CITY OF ALBUQUERQUE

February 6, 2024

RE: 3505 Campbell Farm Lane NW
Grading & Drainage Plan
Engineer's Stamp Date: 09/19/23
Hydrology File: G13D045

Based upon the information provided in your submittal received 01/30/2024, the Grading Plans **are not** approved for Grading Permit. The following comments need to be addressed for approval of the above referenced project:

C100

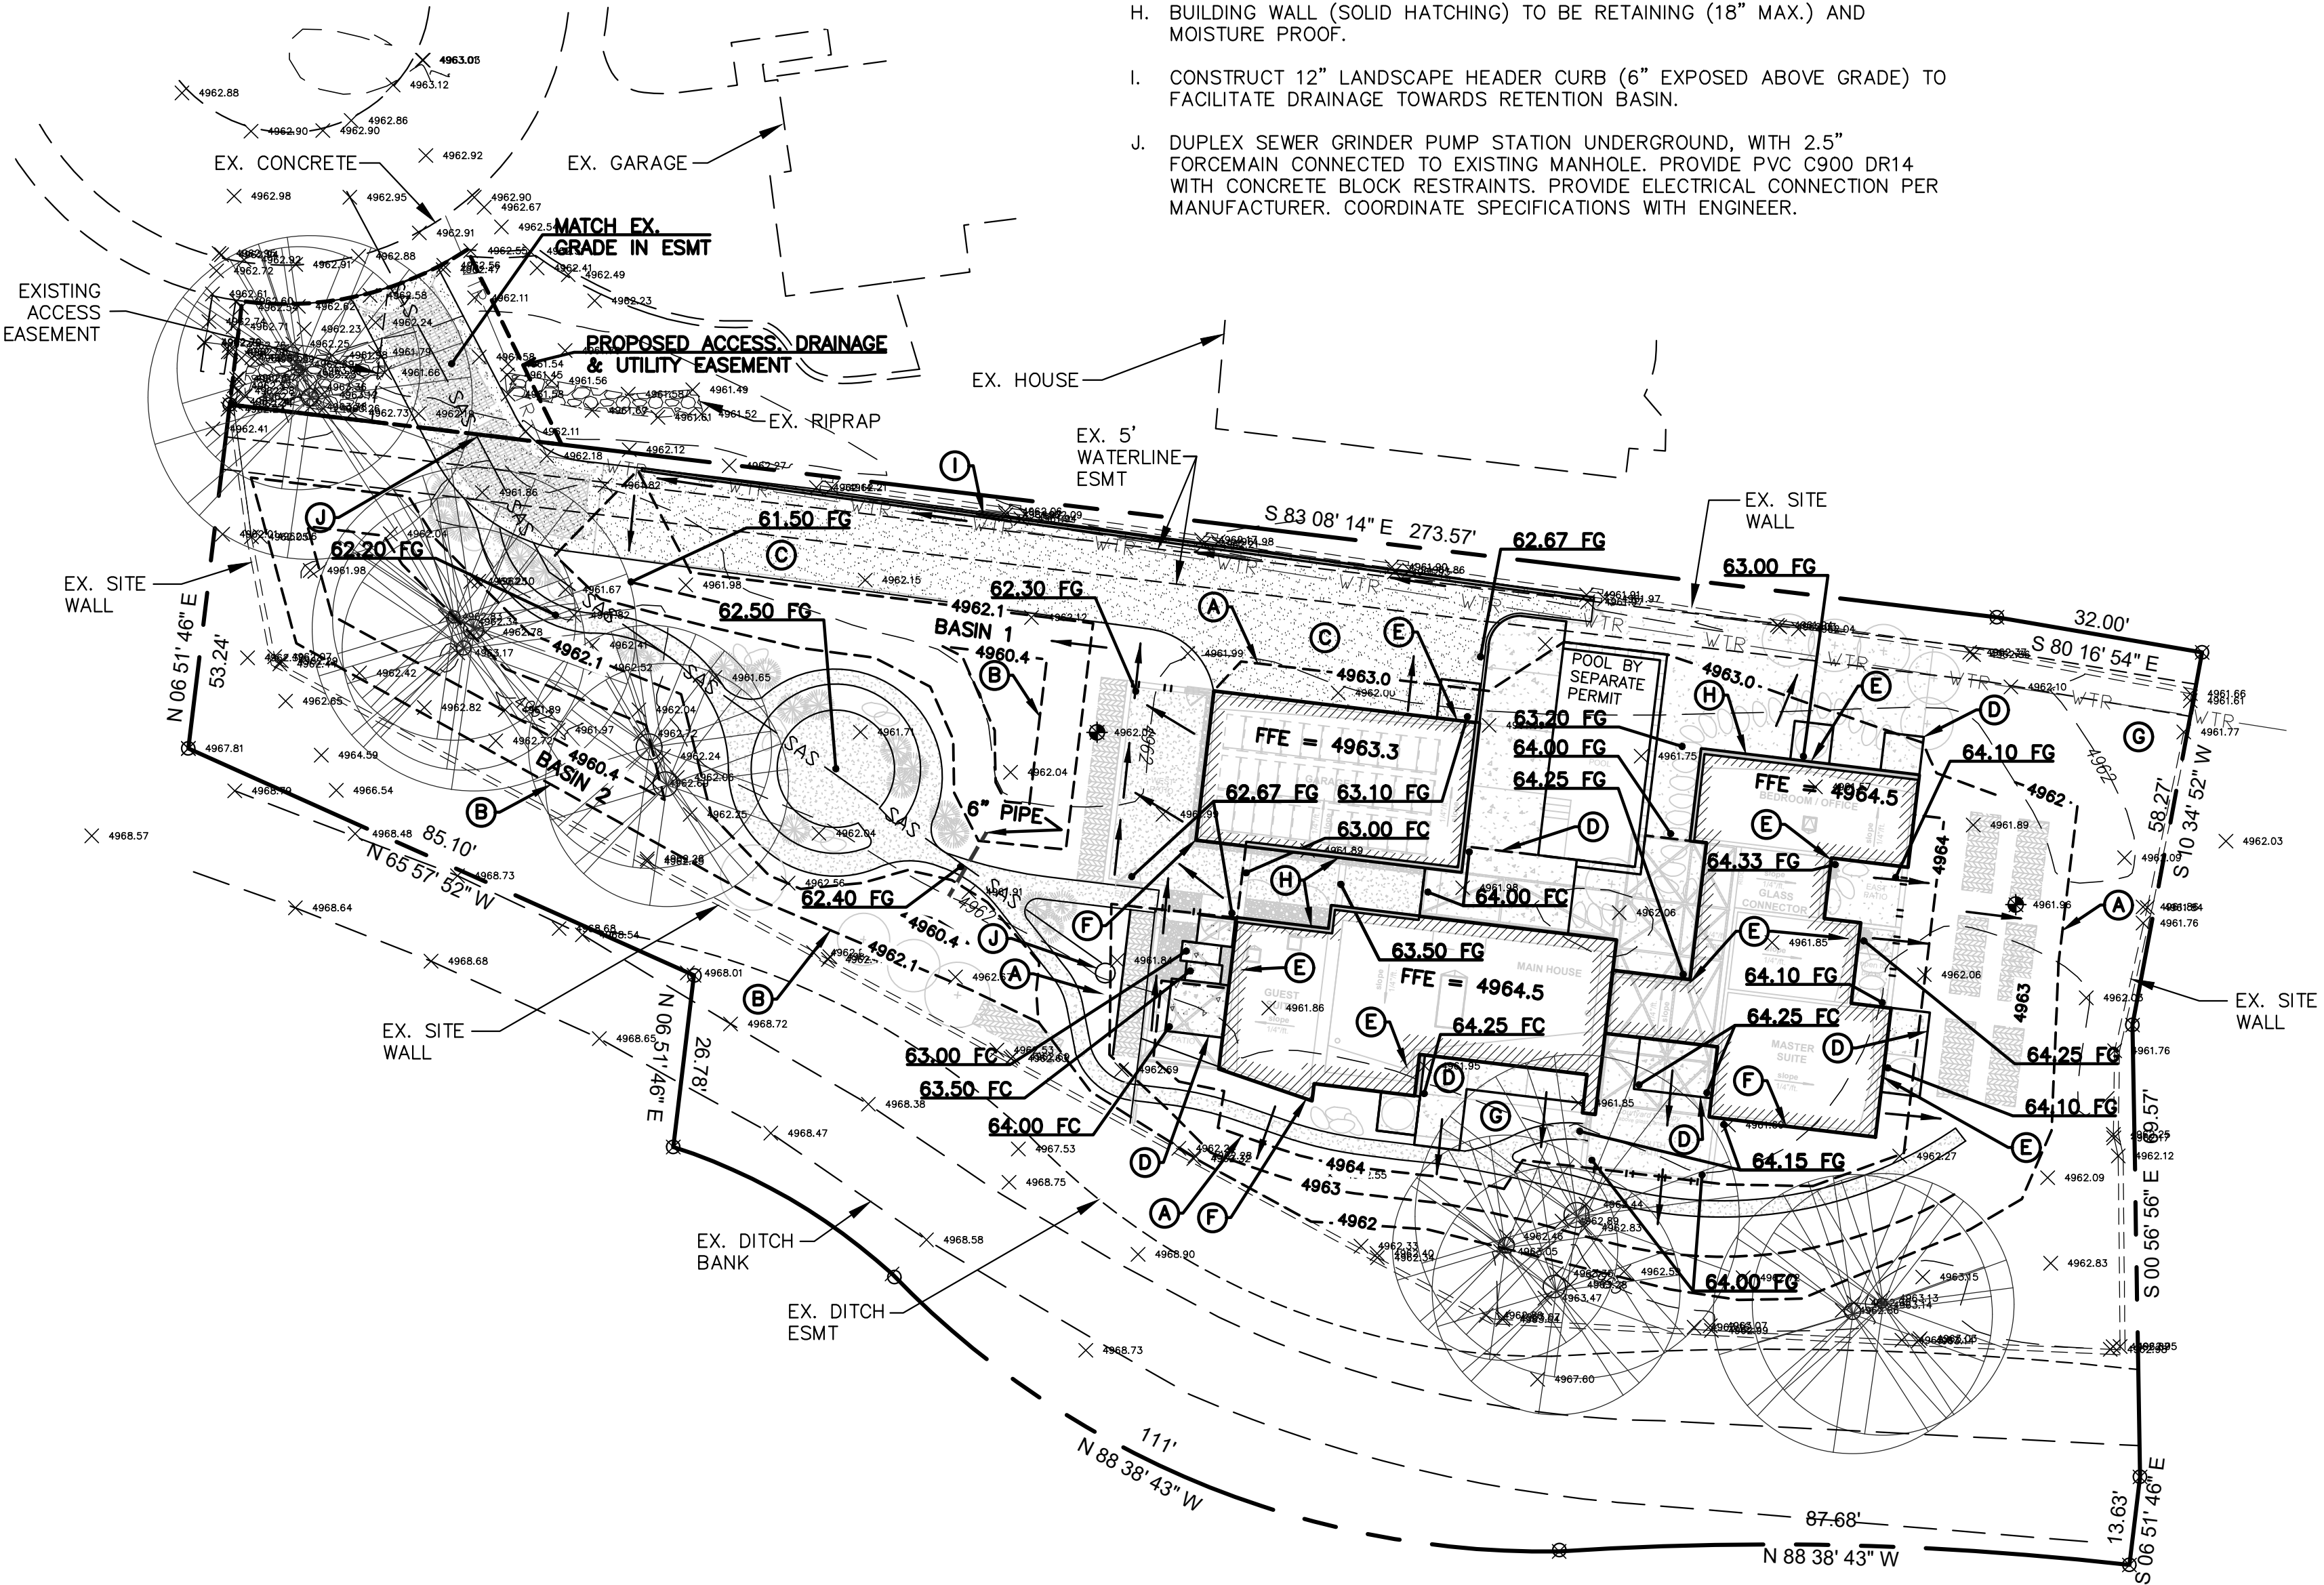
1. Since this site is in the Valley region, please follow Article 6-5 Valley Drainage Criteria of the DPM. The following conditions must be applied to the site:

- The maximum percent impervious of the lot and the contributing area may not be greater than 45%.
- Pad elevation shall be a minimum of one (1) foot above the 100 year 10-day stormwater surface elevation.
- The flow between the front yard and back yard cannot be obstructed. The stormwater must be allowed to equalize to the same level between the front yard and back yard.
- A permanent perimeter wall or barrier around the development is required to contain the 100 year 24 hour storm developed runoff.
- The high point of the street should be four inches above the 100 year 10-day stormwater surface elevation.
